Your Ref EN0101153

**RE:** A new solar energy generating station with an associated Battery Energy Storage System (BESS) and associated infrastructure on land at Frodsham Marsh.

**S56 Relevant Representation – Interested Party**

Figure Title
Indicative Construction Compound and Access Track Layout

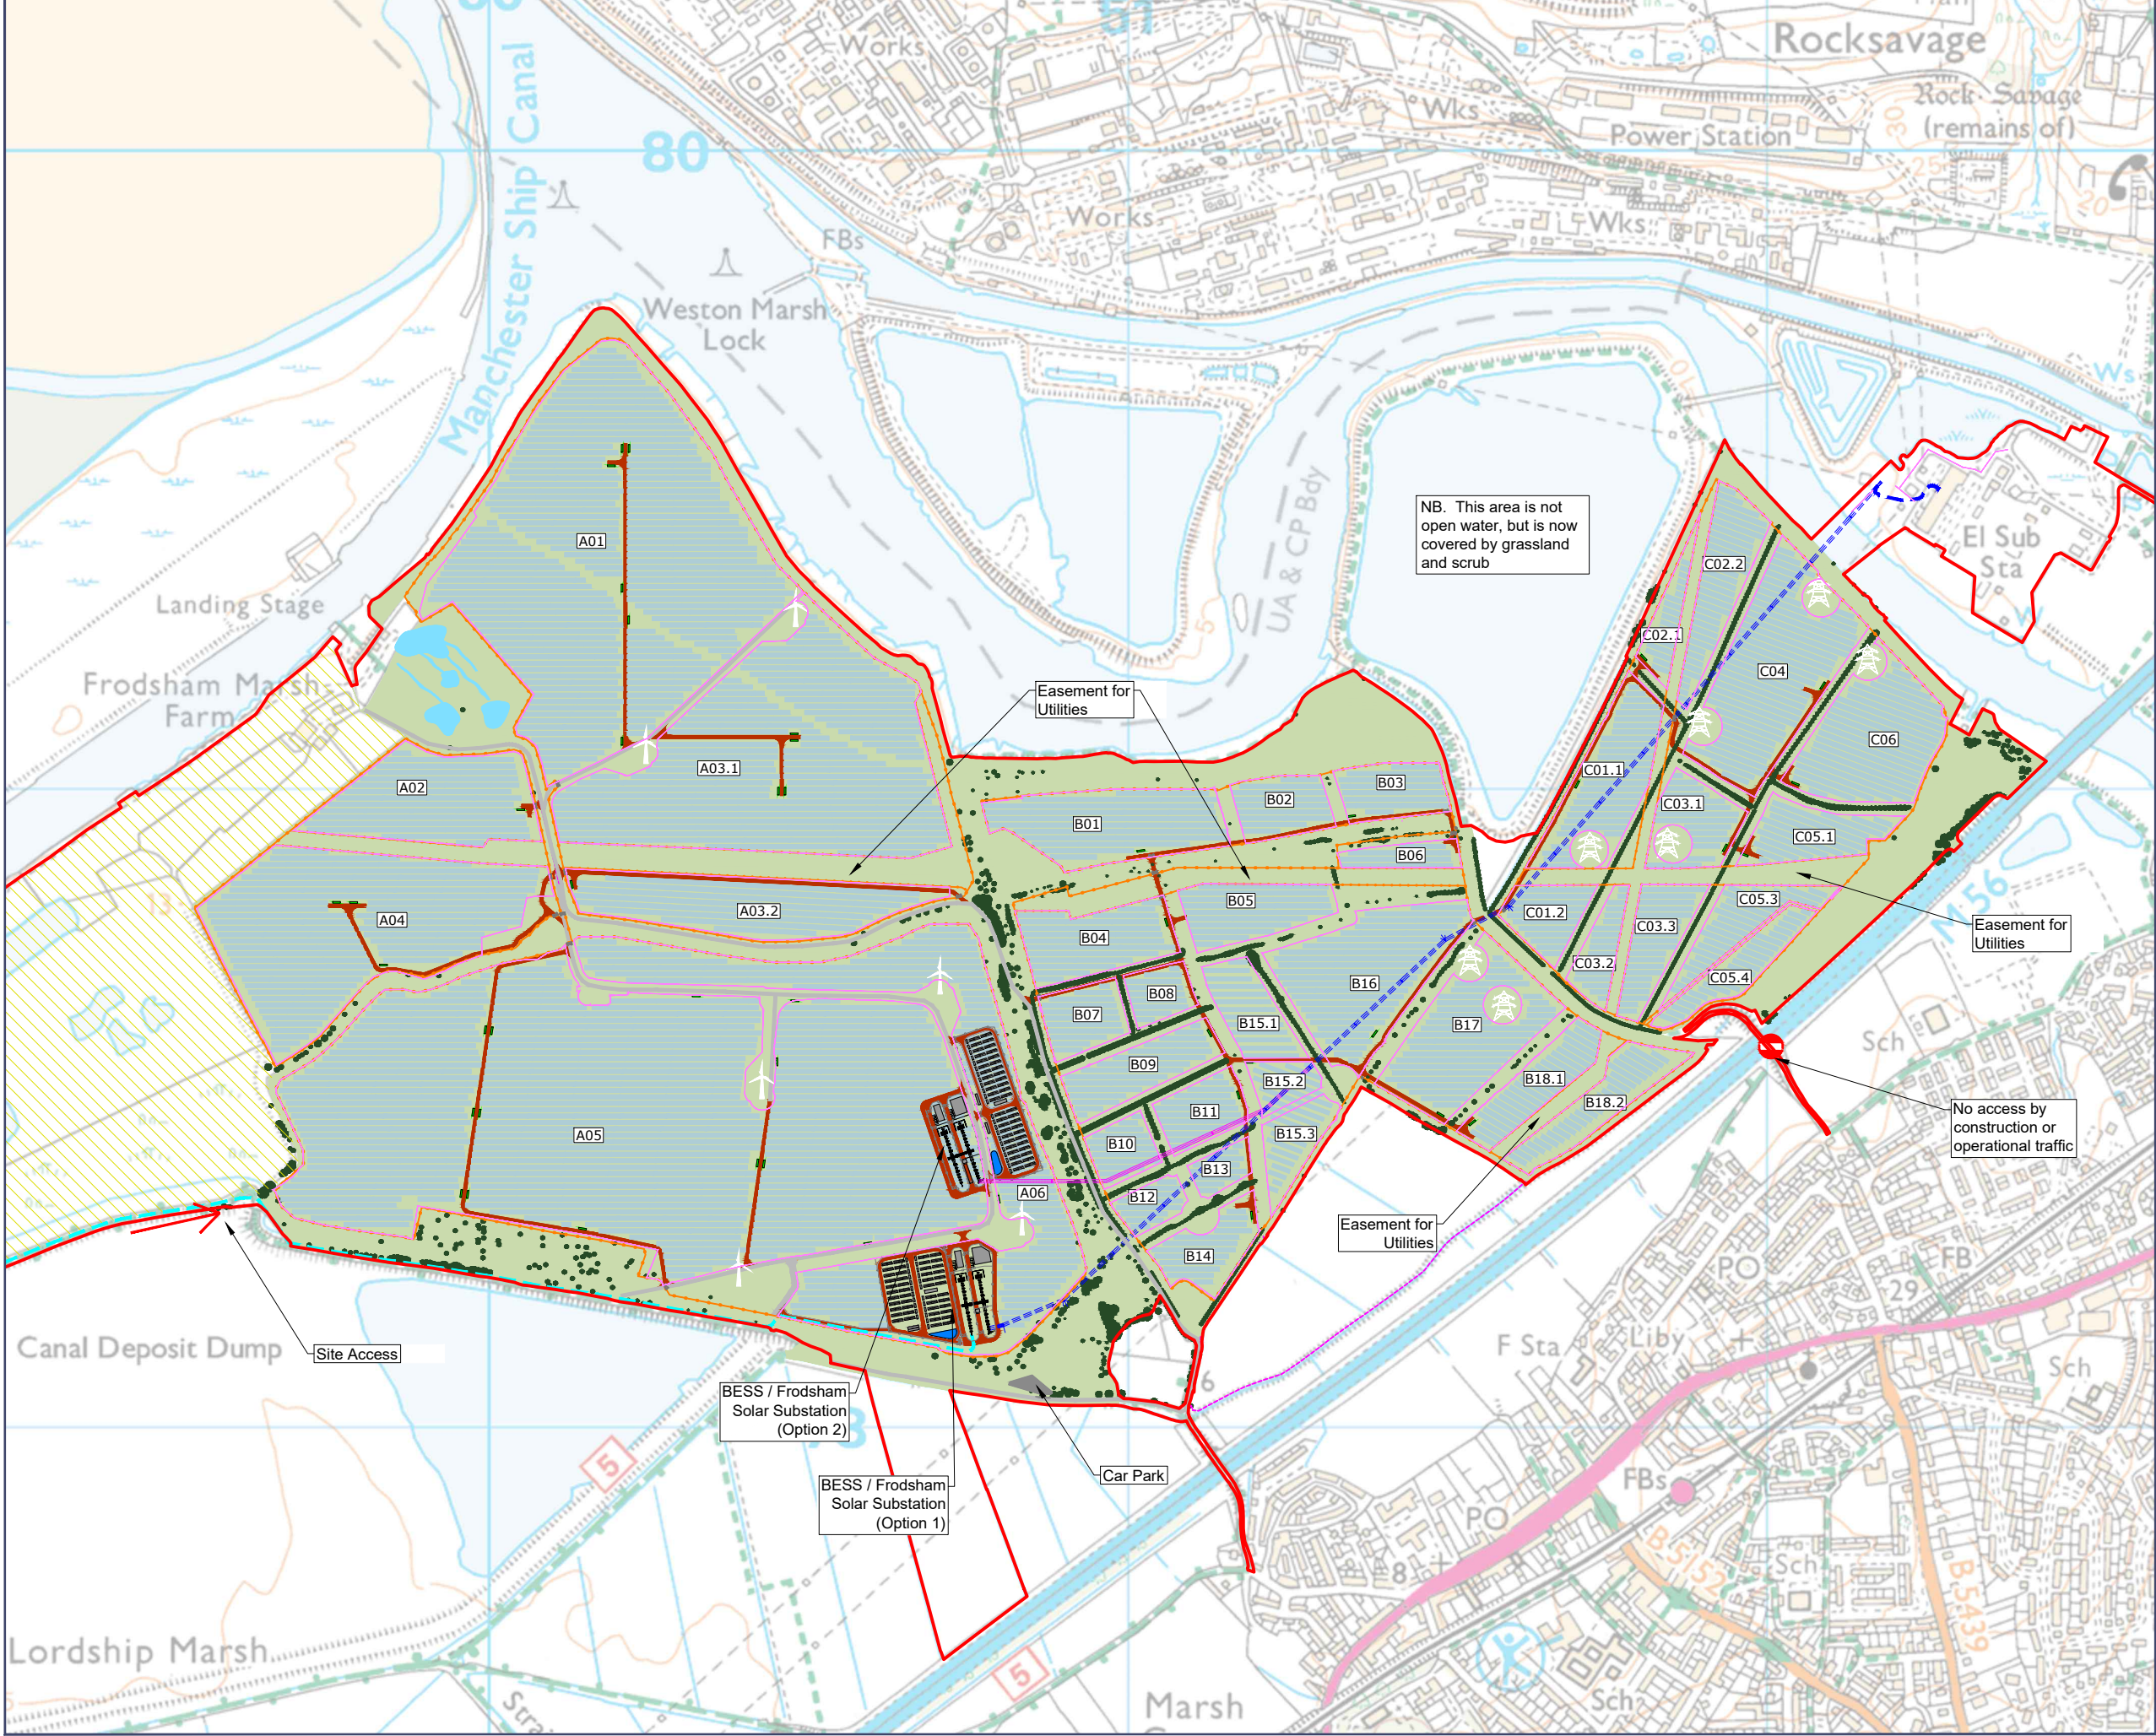
A construction compound is indicated adjacent to the north of Plot 5-17, and it is critical that no part of the works impede or obstruct movement or use of the Access Track at any time.

The Trust is owner of a section of the Access Track that runs along the south of the Weaver Navigation from the north of the SPEN substation (abutting the top of plot 5-17) to Marsh Lock, which interacts with Plot 5-17. The Trust requires use of the shared access track from the A56 to Marsh Lock (5-17, 5-19, 5-20, 5-21, 5-22 and 5-23) for operational use and maintenance of its infrastructure. Therefore, powers in the draft DCO have the potential to interfere with the Trust's use of the Access Track to Marsh Lock which provides access to our infrastructure for operational requirements that is required at all times (24 hours a day, 7 days a week).
